**KIRKLEES METROPOLITAN COUNCIL
INVESTMENT & REGENERATION SERVICE**

DELEGATED DECISION TO DETERMINE PLANNING APPLICATIONS

Reference No:	2024/62/93401/E
Site Address:	Land at, Leeds Road, Dewsbury, WF12 7QB
Description:	Change of use from vacant land to storage of plant and equipment
Recommending Officer:	Nina Sayers

DECISION - REFUSED

DRAWING REF:
24318-D02-A

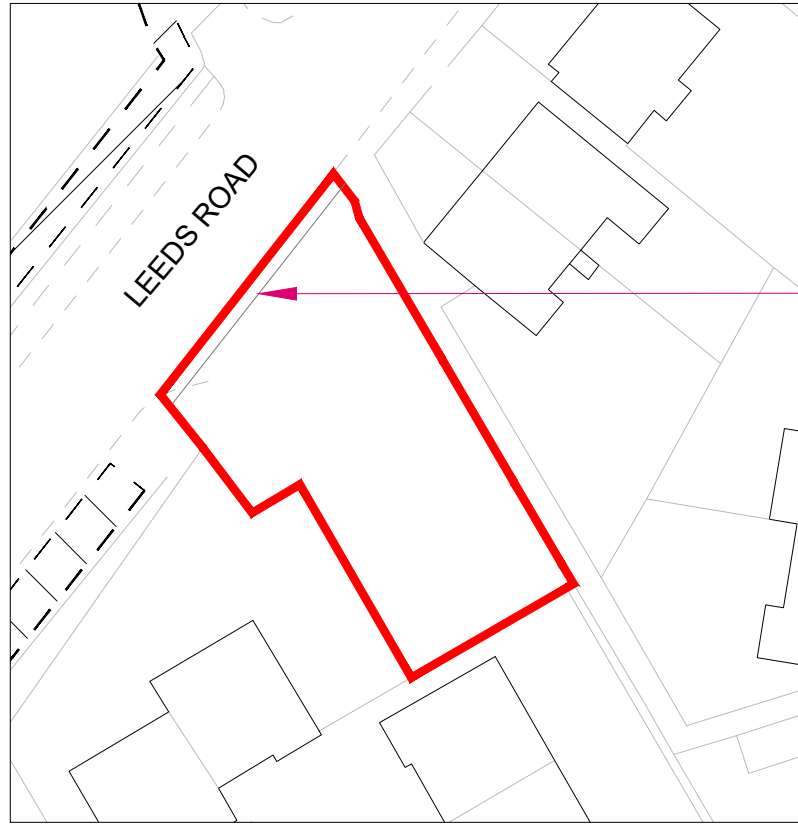
The application site is located on the southern side of the A653 Leeds Road. Leeds Road is a heavily trafficked classified road and bus route connecting Dewsbury with the M62 Motorway at Tingley, Leeds and the wider highway network. The proposals show the red line boundary, and the vehicle swept paths for a 7.5 tonne vehicle which requires the bulk of the site to turn and enter and exit the site in a forward gear. A note on the plan say area to remain clear.

The vehicle swept paths shown for just a 7.5 tonne vehicle require a large part of the site leaving little space for plant and equipment which suggests that the turning space is unlikely to be kept clear for internal turning. Larger vehicles may also be needed to transport plant and equipment to and from the site. It is therefore considered that insufficient internal vehicle turning is available within the site which could result in vehicles needing to reverse onto or off the Leeds Road which is not considered to be in the best interests of highway safety.

Sight lines from the proposed access onto Leeds Road are poor in both directions. This is also not considered to be in the best interests of highway safety."
